Subject: Geologic Hazards Evaluation and Preliminary Geotechnical Investigation
Response to El Paso County Review Comments
Grandview Reserve, Phase 1, Filing 1
Eastonville Road and U.S. Highway 24
Falcon, Colorado
CTL|T Project No. CS19345-115

This letter presents our response to the El Paso County review comments dated May 9, 2023. CTL|Thompson, Inc. (CTL|T) prepared a Geologic Hazard Evaluation and Preliminary Geotechnical Investigation (CTL|T Project No. CS19345-115, dated May 9, 2022) for the proposed Grandview Reserve development located east of Eastonville Road and north of U.S. Highway 24 in El Paso County, Colorado.

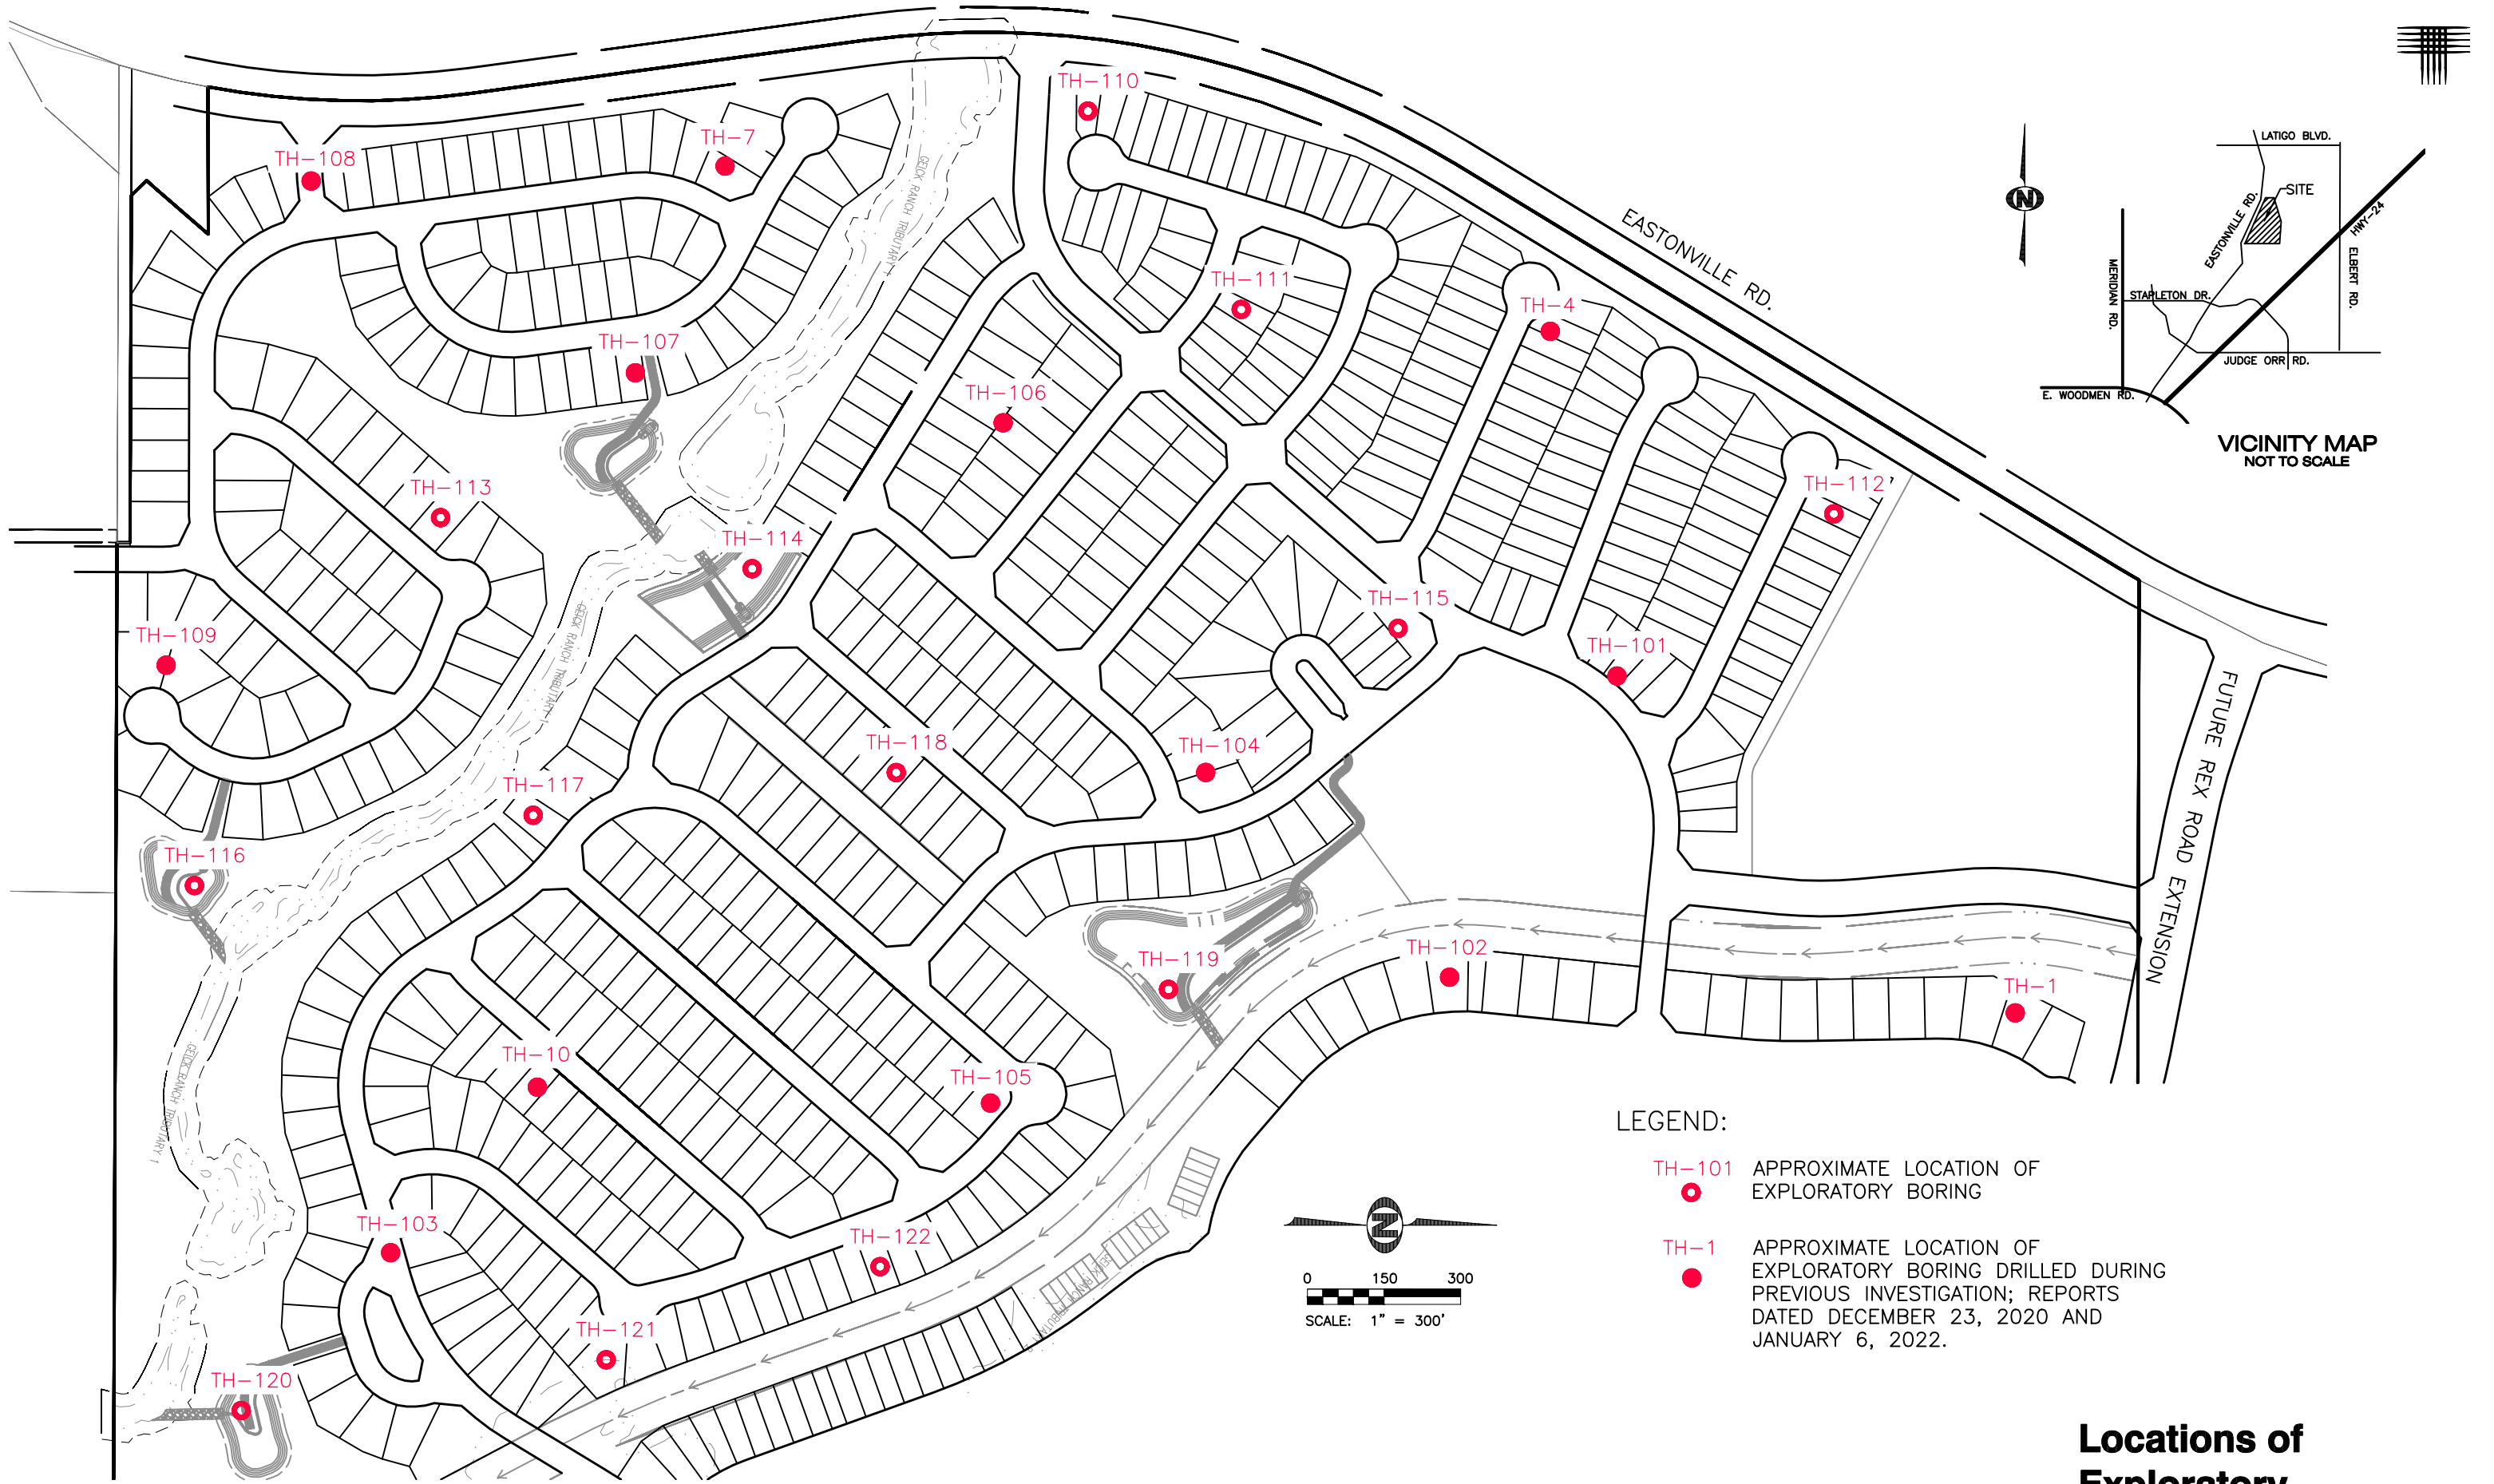
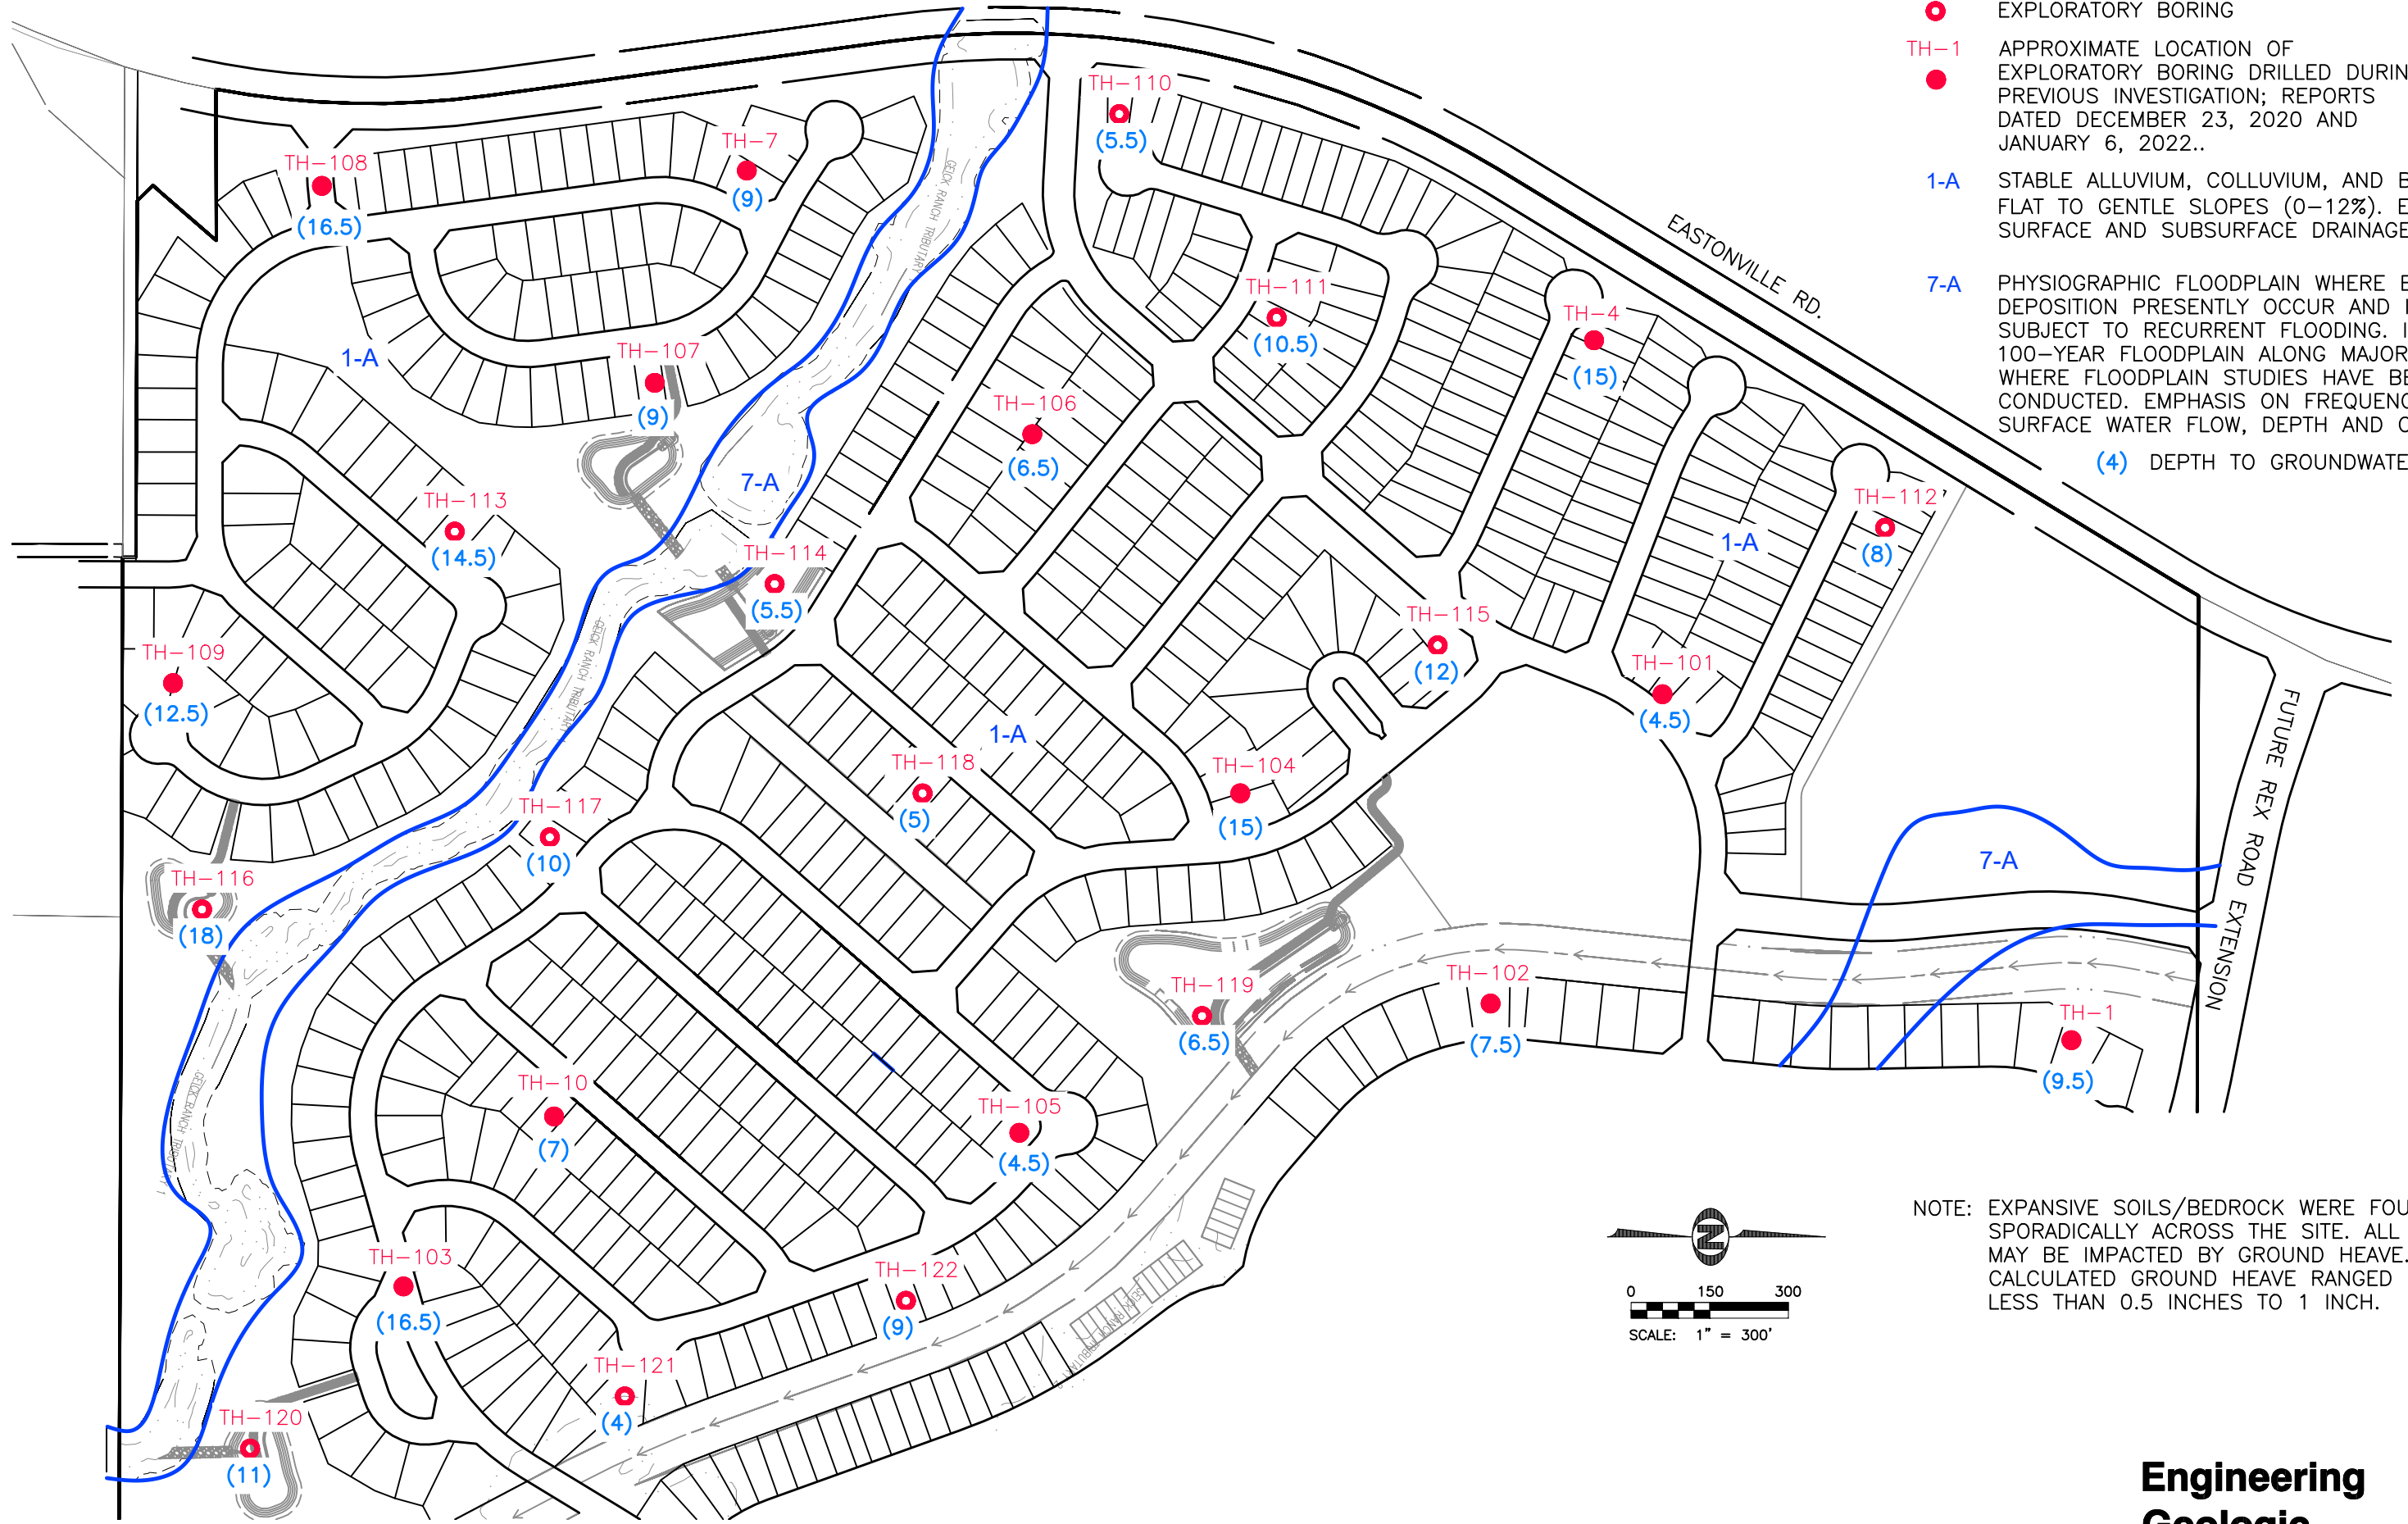
“A figure is missing depicting the various constraint and hazard mapping over the lot layout which was deferred from the prelimplan – see sample.” El Paso County requests that the subsurface conditions, site geology, and each of the geologic hazards including shallow groundwater, hard bedrock, expansive soils, flooding, seismicity, erosion, radon/radioactivity, and recoverable minerals be mapped, along with estimated heave potential.

The referenced report contains a figure titled Engineering Geologic Conditions (Fig. 2). The figure indicates areas of the mapped physiographic floodplain and areas of stable alluvium. We also revised Figure 2 (attached) to clarify our interpretation of the engineering geology and depict where flowing water may be present (in the channel) and where seasonally shallow groundwater is likely (remainder of site). A note is indicated on Figure 2 that states “Expansive soils/bedrock were found sporadically across the site. All lots may be impacted by ground heave. Total calculated ground heave ranged from less than 0.5 inches to 1 inch.” This note was included because the Dawson Formation, which underlies the site at relatively shallow depths, contains interbedded and discontinuous layers of expansive claystone bedrock. This material cannot be mapped with any reasonable degree of accuracy and it should be expected that expansive claystone may be encountered anywhere on the site. As stated in our report, lot specific soils and foundation investigations should be performed, following completion of overlot grading, to determine where expansive claystone is present and provide recommendations for mitigation.

approximate depth to groundwater below the proposed finish grades. We also provided a figure titled Basement Construction Recommendations (Fig. 4), that depicted lots that are unsuitable for basement construction based on our groundwater data and analysis. We understand basement construction is not currently proposed. We have included a new figure attached with this letter, titled Surficial Geologic Conditions (Fig. 5), that delineates surficial geologic units across the site based on mapping and site reconnaissance. Considering the variability within the Dawson Formation, a detailed map of subsurface conditions beyond the surficial geology that is mapped in Fig. 5, cannot be produced. Additionally, the remaining geologic hazards presented in the report such as hard bedrock, seismicity, erosion, and radon/radioactivity cannot be mapped. These are generally regional hazards and it isn't possible to delineate the extents of each of the geologic hazards on every site. Attempting to do so would falsely suggest that these hazards may be possible in portions of the site and not possible in other portions of the site. A discussion of these hazards is provided in the referenced report.
